Town & Country Planning Act 1990 (as amended)
Town and Country Planning (Development Management Procedure) (England) Order 2015
Application for approval of details reserved by conditions imposed on planning reference
BR/270/16/PL relating to condition no. 3 (Drainage), 4 (Arboricultural Protection Measures) & 6
(Materials & Finishes)
Villa Maria Campbell Road, Bognor Regis,

Arun District Council have decided to **REFUSE details reserved by condition for the following reasons:**

PROPOSED SITE PLAN
(1:100)

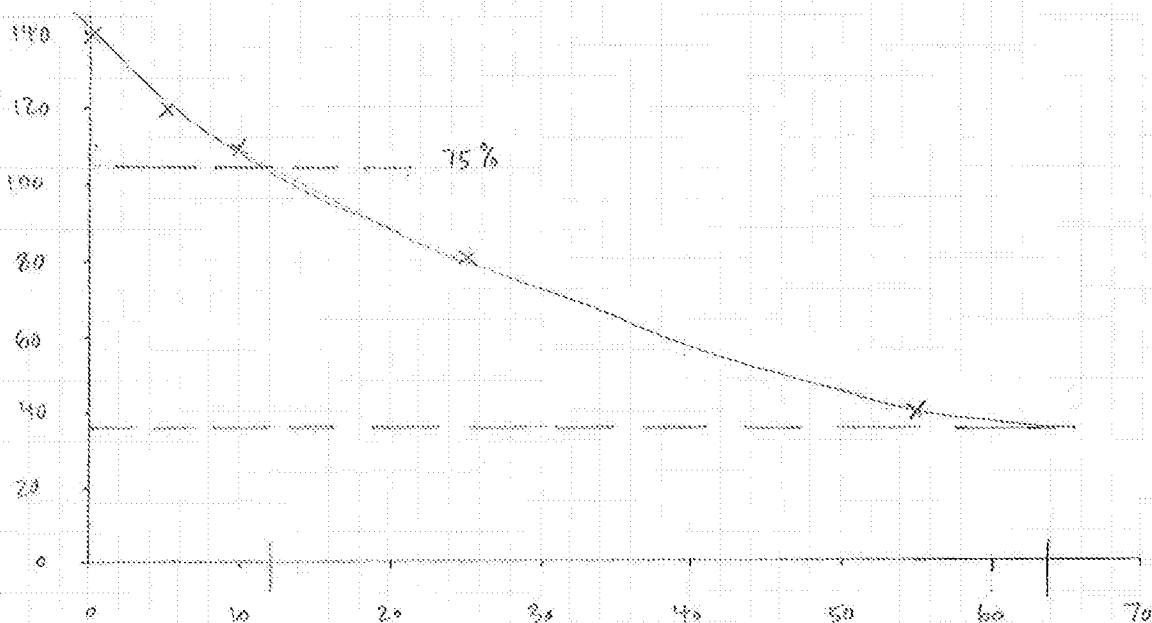
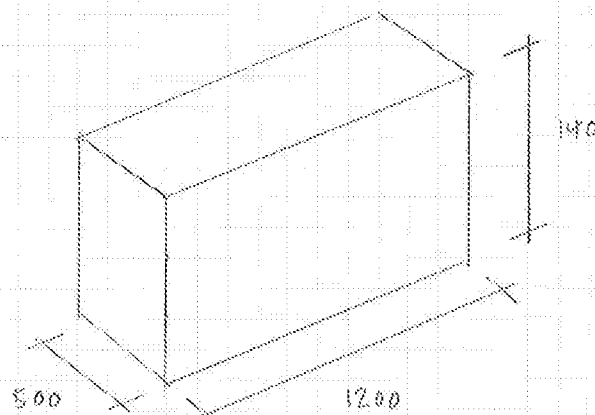
The submission details percolation test that evidence suitable rates of infiltration for

soakaways to be used are prevalent. However, the submission then goes on to state there is insufficient space for soakaways so discharge to sewer will occur. This is not acceptable. Having reviewed previous submissions it is clear that the pre-commencement condition was not abided by. This is not however now justification to not follow the hierarchy for sustainable drainage.

There are possibilities to use permeable paving on site, and following conversations with building control to possibly drain some roof water into these.

Based on this, I do not recommend that the condition is discharged. And would recommend the developer contacts us to discuss how to correctly drain the site.
